Planning Application Ref: BN/100/21/T

Location: Barnham Court Lodge, Church Lane, Barnham, West Sussex, PO22 0BP

Description of works: Various works to various trees

Barnham Court
Lodge
Church Lane
Barnham

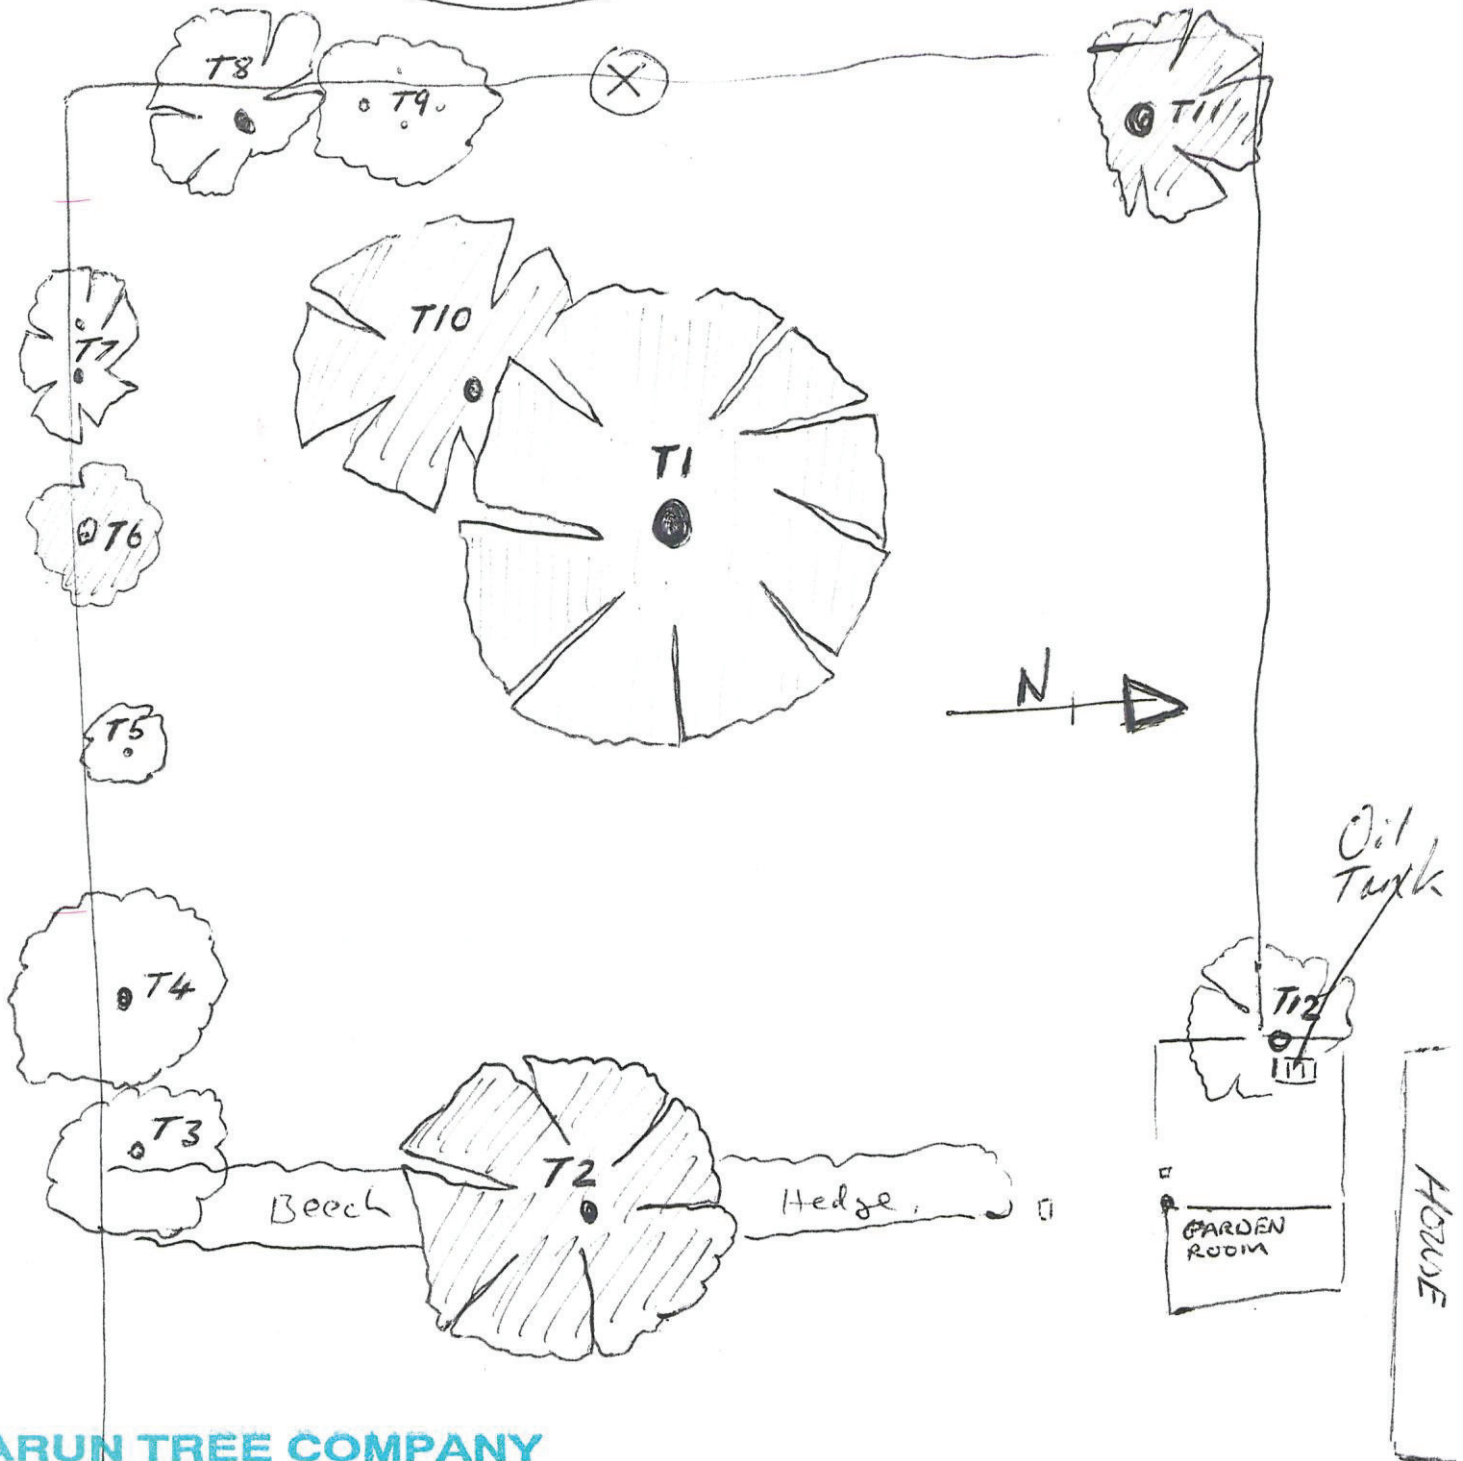
- The applicant has employed Arun Tree Company Ltd., to prepare and submit a tree survey and plan. This is comprehensive and includes a detailed work specification with satisfactory reasons given for each item.
- Those various trees listed for work are growing within Church Lane, Barnham Conservation Area and no Tree Preservation Order applies. As such, I treat this application as a section 211 notice.
- They are discreetly located within the expansive gardens of the property. Collectively they have limited visibility from neighbouring properties and to users of publicly accessible land. As such, they possess little public amenity value but do contribute to the garden setting.

-
- Advice is sought on the future management of ash trees on the site; given the probability of future disease 'Chalara ash dieback'.

- I am satisfied that the works proposed are justified and if undertaken to a high standard and at the right time - will not result in character of the surrounding area being diminished.
- I raise **No Objection** to the works that have been applied for and see no reason to make a Tree Preservation Order in this instance.

To support a proposal for removal of trees at this property, with Chalara ash dieback, I would require the following information:

1. The applicant will need to provide evidence (usually photographs of high quality) which clearly demonstrate the presence of fungus *Hymenoscyphus fraxineus* and associated disease.
2. The applicant will need to provide evidence (usually photographs of high quality) which demonstrate the tree is within Ash Health Class 3 or Class 4 as detailed on p33 of The Tree Council's Action Plan Toolkit. Those are described as having 50%-26% remaining canopy and 25%-0% remaining canopy respectively.

If both tests can be met, then I would support action to fell as an exception (dangerous trees or branches).
